Submission for Job: #6010 SSD 6010 - One Residential Building (Student Accommodation) within Darling Drive Plot

Site: #2824 SICEEP Site, The Haymarket; Darling Drive, Sydney

SSD 6010 - One Residential Building (Student Accommodation) within Darling Drive Plot

30 July 2013

SHADOW DIAGRAMS: PERSPECTIVE, SHOWING THE PEAK, WINTER SOLSTICE

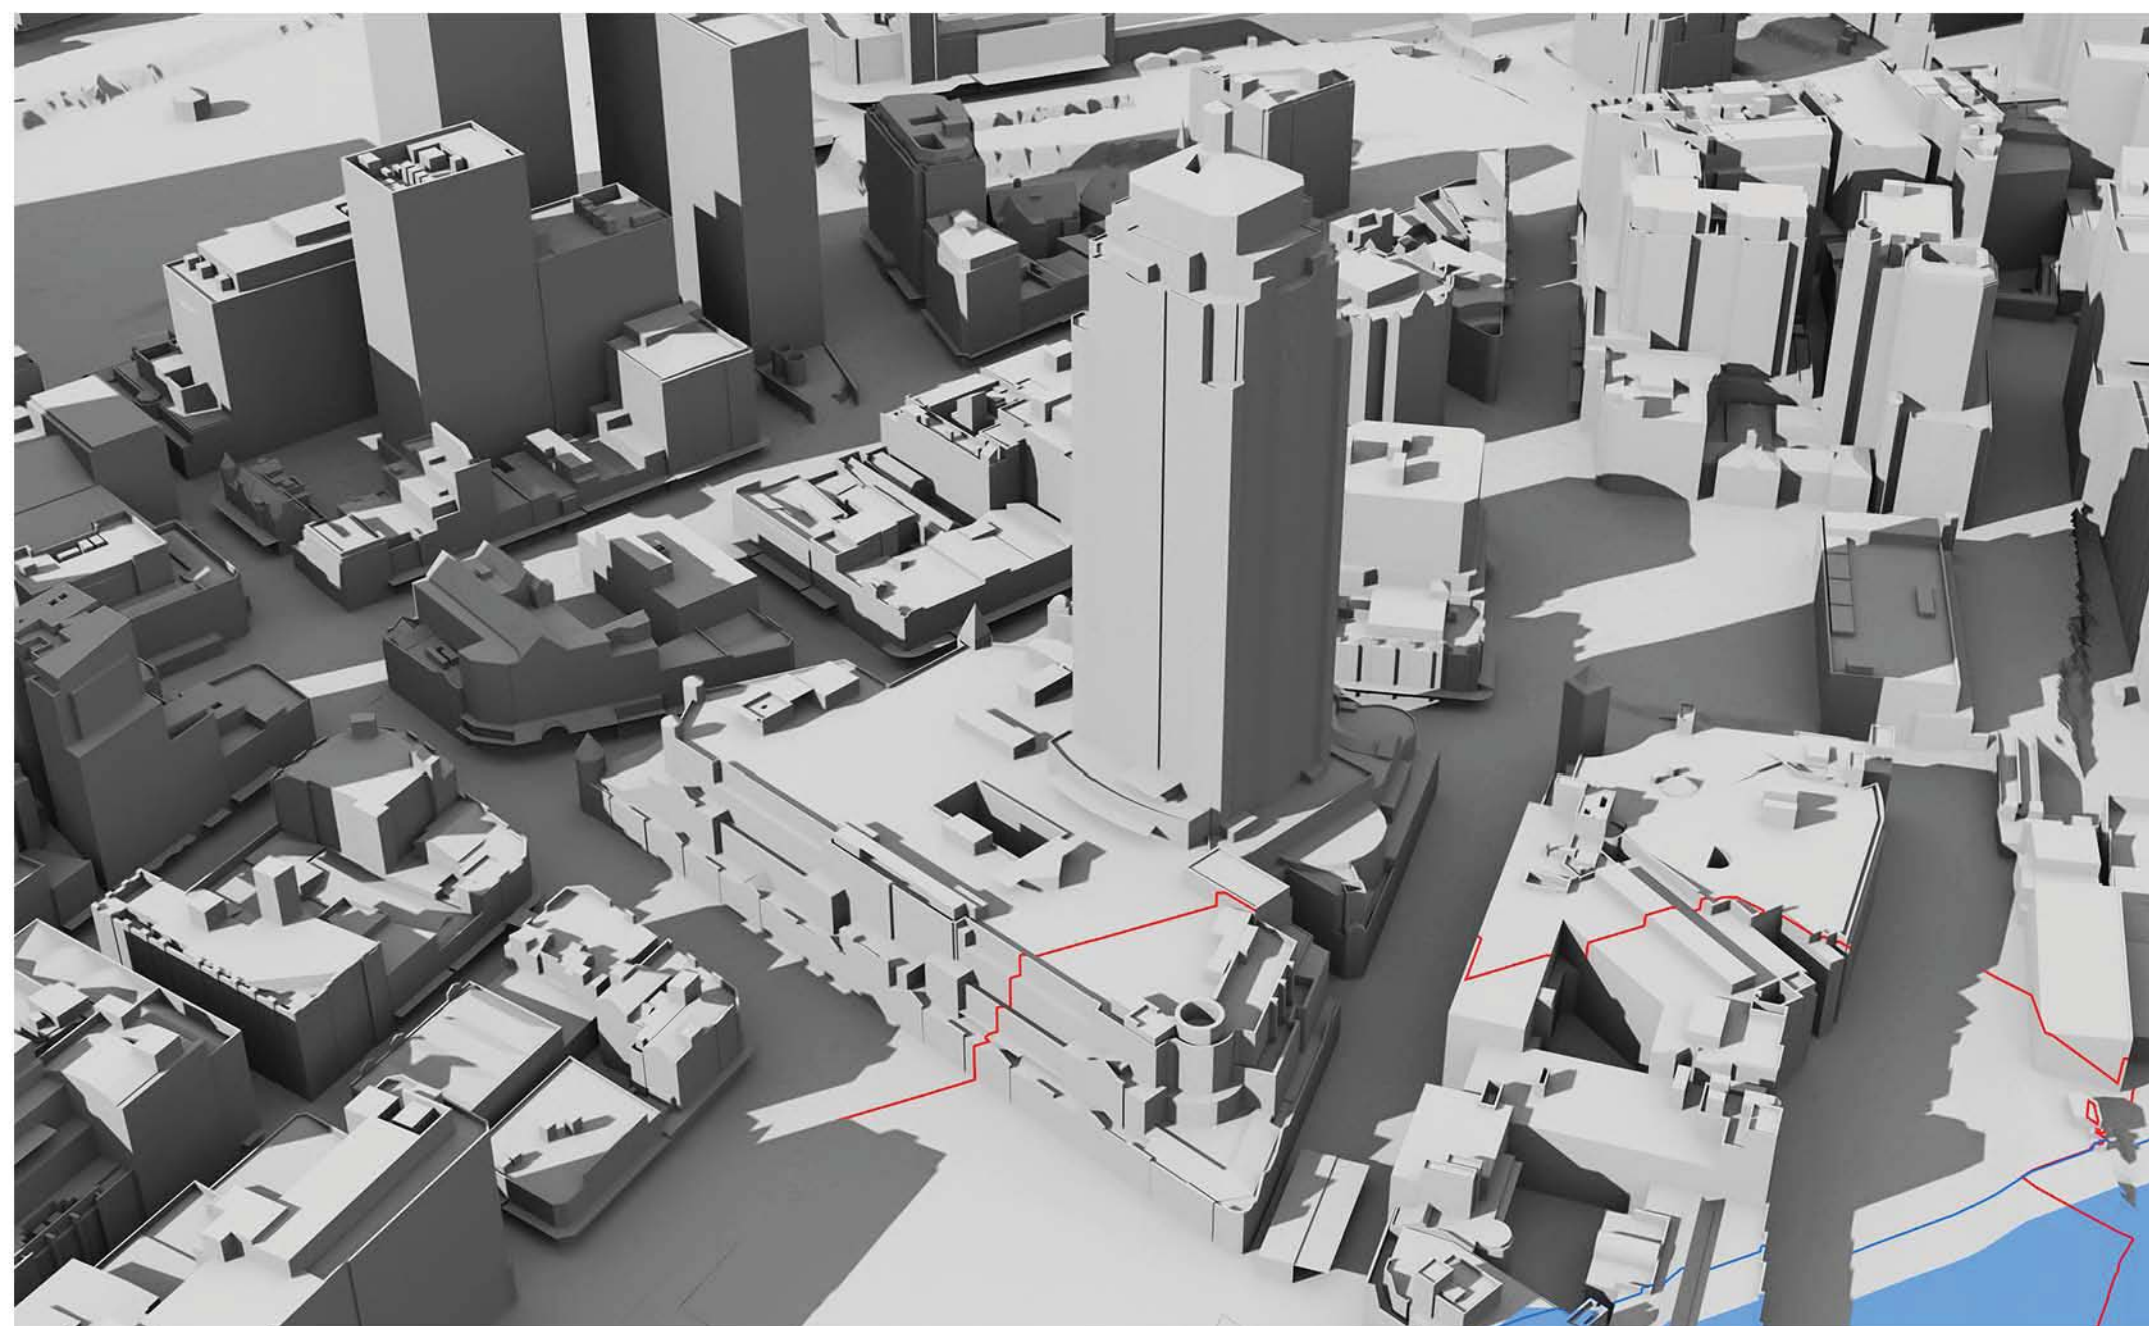
At 9am, 10am and 11am the west façade is totally in shadow due to other parts of The Peak building itself.

At 12pm there is still substantial existing shadowing on the west façade caused by the irregular shape of the west facade.

At 1pm the existing shadowing has been substantially removed, but not totally removed.

It can be concluded that some single aspect apartments on the west façade and some south-west dual aspect corner apartments currently receive less than 2 hours direct sunlight to habitable rooms and 50% of the private open space between 9am and 3pm on 21 June.

At 9am, 10am and 11am the west façade is totally in shadow due to other parts of The Peak building itself.

At 12pm there is still substantial existing shadowing on the west façade caused by the irregular shape of the west facade.

At 1pm the existing shadowing has been substantially, although not entirely, removed. However, overshadowing of lower levels of the west façade by the concept proposal parameter plan shadows for the N,NE and SE plots has already started.

By 2pm the existing shadowing has been totally removed. However, overshadowing of the west façade by the SSDA4 and SSDA5 buildings has appeared and risen further up the west façade than the concept proposal parameter plan shadows for the N,NE and SE plots, which is still present.

At 3pm, the proponent states correctly that 45-45% of the western façade is overshadowed by the SSDA4 and SSDA5 buildings.

It can be concluded that, as a result of combination of the proposed development with existing shadowing of the west façade, some single aspect apartments on the west façade and the south-west dual aspect corner apartments which currently receive less than 2 hours direct sunlight to habitable rooms and 50% of the private open space between 9am and 3pm on 21 June will suffer additional overshadowing. It is beyond our skills to count the number of such apartments. We note that the proponent has made no attempt to do so.
